DECISION NOTICE

Application Ref: WA/79/20/PL

Spindlewood
Yapton Lane
Walberton
BN18 0AS

Demolition of existing dwelling & erections of 8 No. new dwellinghouses with associated landscaping & parking (resubmission following WA/30/20/PL). This application is a Departure from the Development Plan & is in CIL Zone 3 and is CIL Liable.

Drawing.
Proposed Site Plan

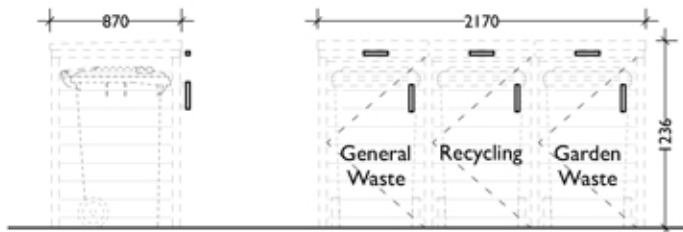
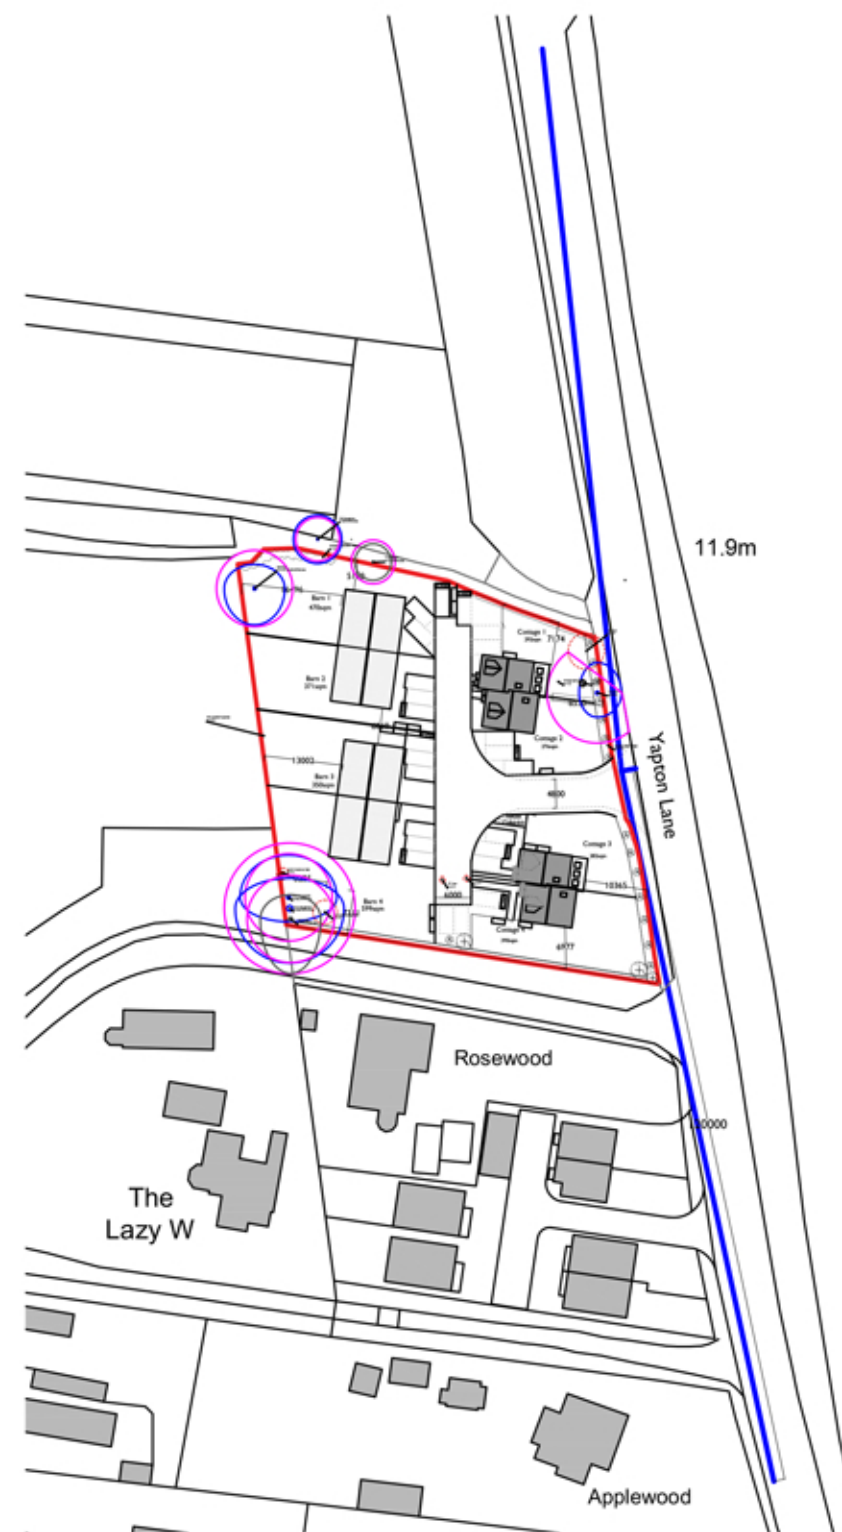
The amount/density of development on the site and the orientation and layout of the proposed development would not accord with the general pattern of development along Yapton Lane. The proposal would therefore result in the character and appearance of the area being unacceptably affected contrary to policies D DM1, D SP1 and QE SP1 of the Arun Local Plan and policies HP11 & HP13 of the Walberton Neighbourhood Plan.
